From: Damian Manhertz
Sent: 27 July 2010 16:24
To: Planning
Subject: FW: S6/2010/1359/MA - DHL - Frobisher Way

From: Roger Evans
Sent: 27 July 2010 16:22
To: Damian Manhertz
Subject: S6/2010/1359/FP - DHL - Frobisher Way

Dash Dot Architecture Ltd The Loft, 31 Townsend Road, London, N15 4NT t: 07966 301 381 e: m_j_young2000@yahoo.co.uk			
	PROJECT	CLIENT	DATE
	DHL Hatfield	DHL	May 10
	DRAWING	SCALE	DRAWING NO
	Proposed Yard Layout	1:1000 / 250 @ A3	(90)06
			REV
			A

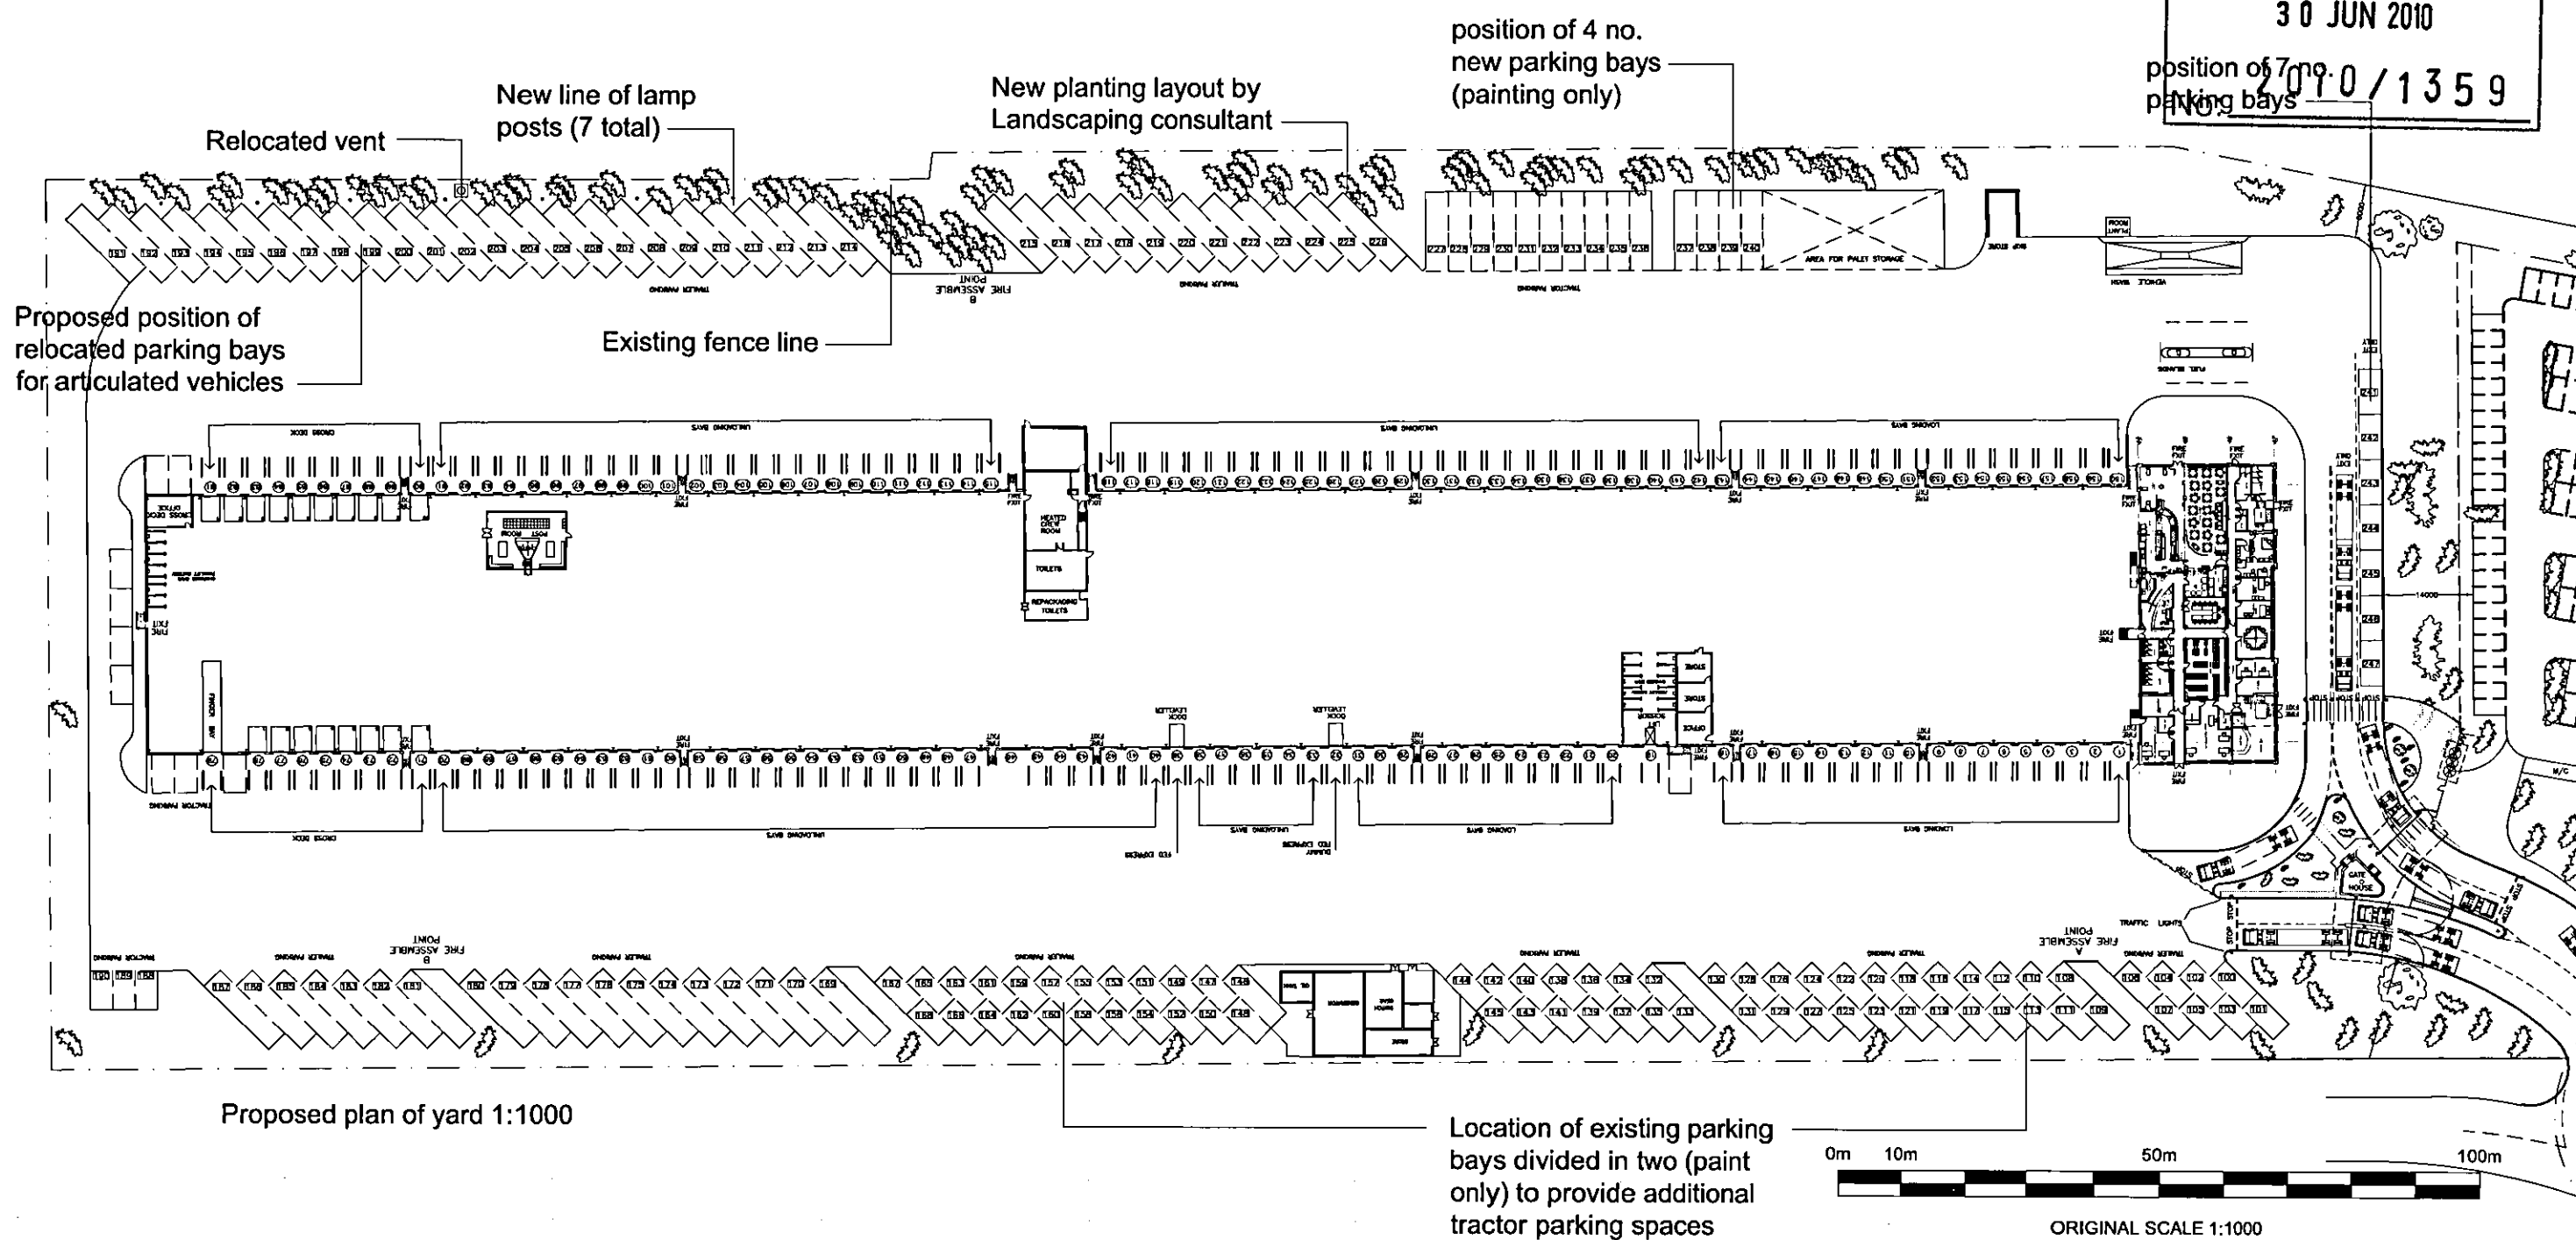
The proposed changes would result in some parking bays being provided closer to the houses, but no closer than the roadway itself which runs along the Northern end of the building. I have considered the possible impact noise issue if trailers were to be uncoupled at these closer parking positions, but do not believe the noise generated would compromise the attenuation standards provided.
